Lancashire Archaeological
Advisory Service

Your ref: 3/2017/0319

Planning Application 3/2017/0319: Demolition of existing kitchen outrigger and replacement with new two storey extension to side and rear to include six new bedrooms on first floor. New extension to continue over existing first floor terrace. Insertion of four new rooflights to front elevation; Waddington Arms, Clitheroe Road, Waddington BB7 3HP

Existing Plans & Elevations

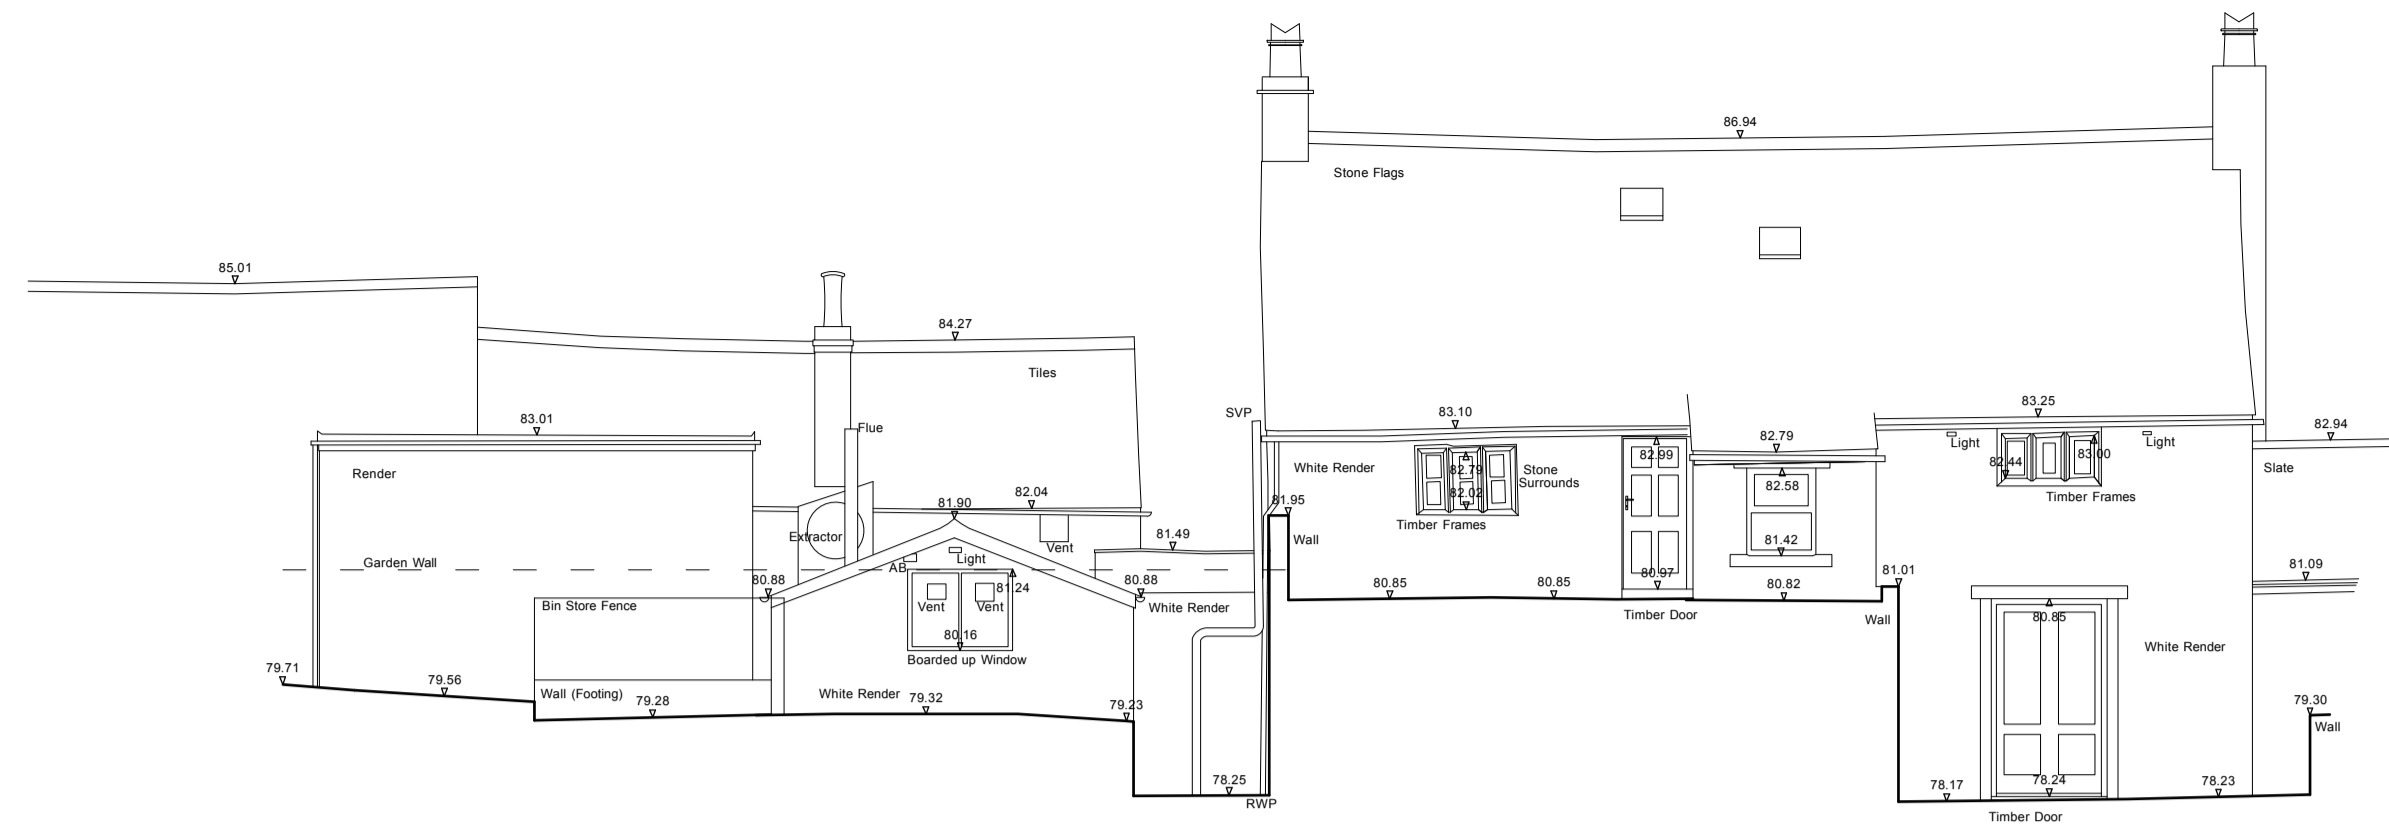
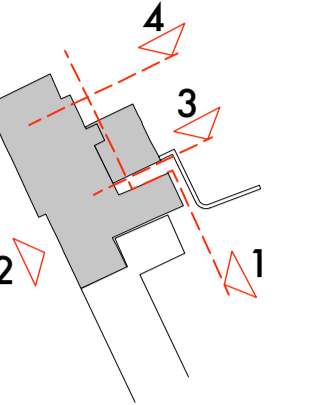
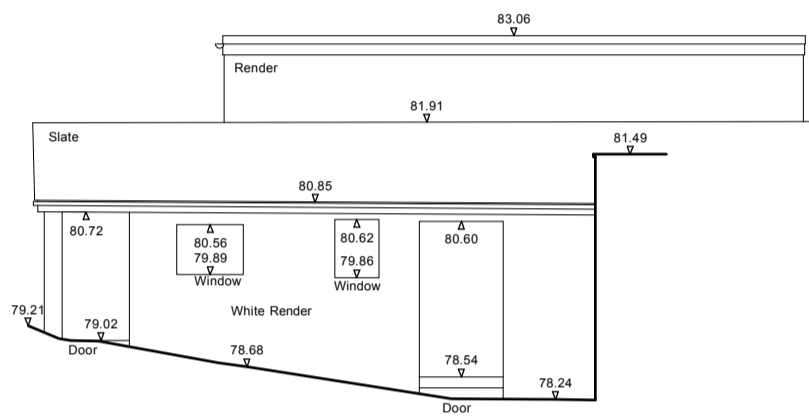
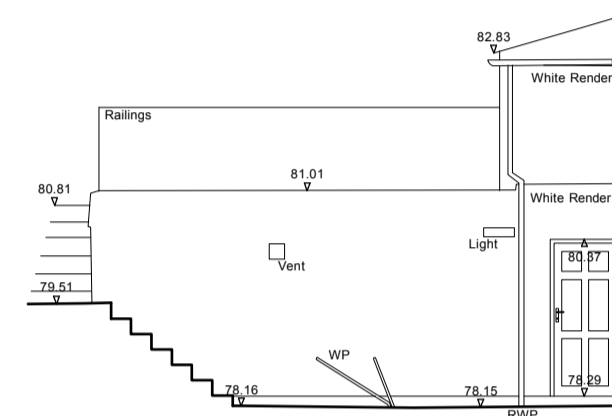
The rear of the building is not described in any detail, with the only information provided being that '*... A rear toilet block and cellar extension to the main part was built in the later C20th*' (Heritage Statement, pp.5-6). Examination of the drawings supplied with the application (some of which are reproduced in the heritage statement), would show, however, that the rear section of the main building retains two three-light chamfered and

mullioned windows, apparently of 17th-18th century type, at first floor level. At least one of these windows is impacted by the proposed extension and is not shown in the drawings 'as proposed'. The significance of this alteration is not assessed.

The rear of the 'stables and coach house' section in the drawings is partly obscured by an adjacent flat-roofed building, but a chimney can be seen which presumably corresponds to the fireplace seen on the rear wall of the front part of that building on the plans. A fireplace in this position would be odd in a stable or coach house, so either that interpretation is wrong or the fireplace and chimney are an insertion. It would appear from the plans as proposed that the chimney is to be lost, although the ground floor chimney breast appears to be retained. There is no indication of the date or significance of this feature.

The drawings would also suggest that the rear outrigger which presently houses the kitchen and a store is an addition to the front section. This element is not described in the heritage statement and its significance and the impact of the proposed changes has not been assessed.

We would recommend that the Heritage Statement is revised to include

- (i) An outline phasing of the building;
- (ii) A description and assessment of the heritage value of the rear of the building, with particular reference to those elements which are proposed to be lost, altered, built over or otherwise changed;
- (iii) An assessment of the significance of the proposed changes;
- (iv) A series of photographs and drawings of the front, rear and interior of the building to support the assessments of heritage value and significance, and to allow the impact of the proposals to be clearly understood.
